Our Ref: MF/sb/Powell
Your Ref:
Date: 14 August 2015

**Re: Application R/170/15/HH – Single Storey Rear Extension,
Side Car Port and Rear Glass Roofed Veranda at 12
Amberley Road, Rustington**

12 AMBERLEY ROAD
 RUSTINGTON BN16 2EF
 FOR: Sylvia Mills
 JOB: Single Storey Extension
 TITLE: Proposed Ground Floor
 SCALE: 1:50 DATE: JUNE 15
 DRG. N° SM/15/04

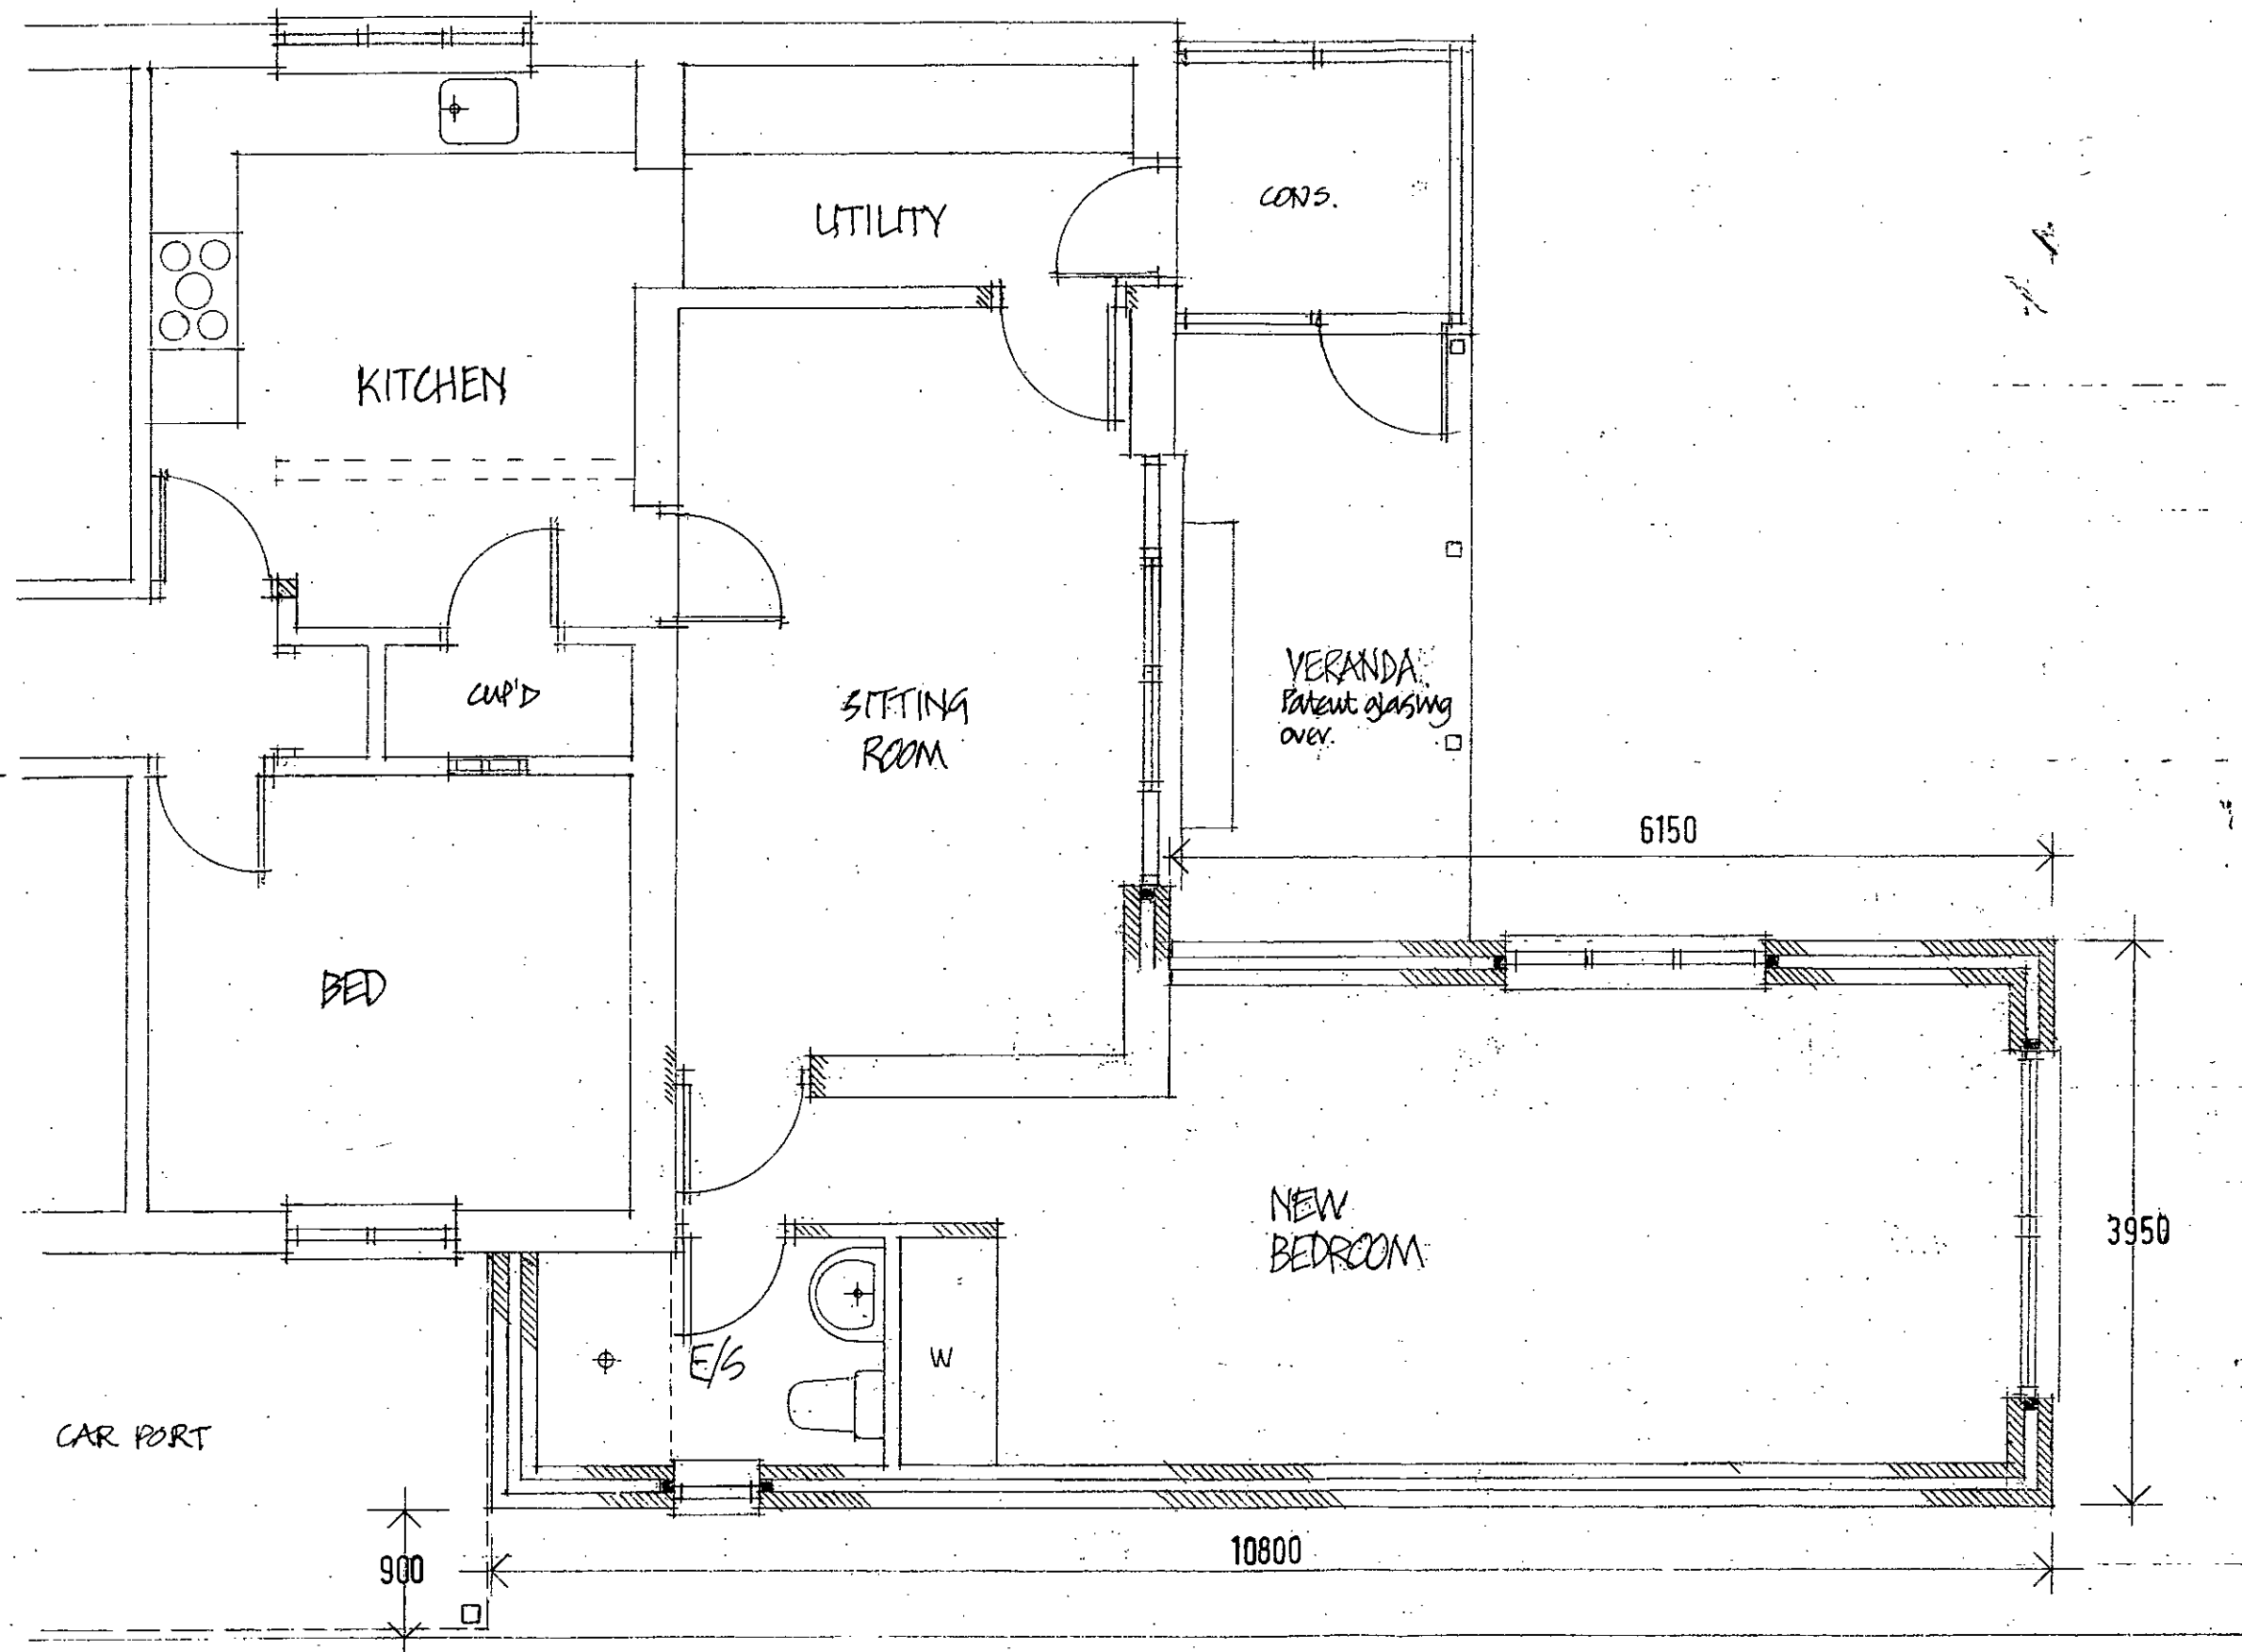
We act for Mr & Mrs Powell the proprietors of 10 Amberley Road. We write on their behalf in order to make written representations in relation to the Planning Application by their neighbour at 12 Amberley Road. Our clients have viewed the Application and plans and it is quite clear that if the Planning Application is allowed then this will block significant light to our clients' kitchen window (particularly from the car port and the pitched roof). This will have an impact upon our clients view from their premises and will devalue their property.

Our clients believe that their neighbours should compromise and place the car port back so that it does not block light to their window and the extension should be constructed with a flat roof.
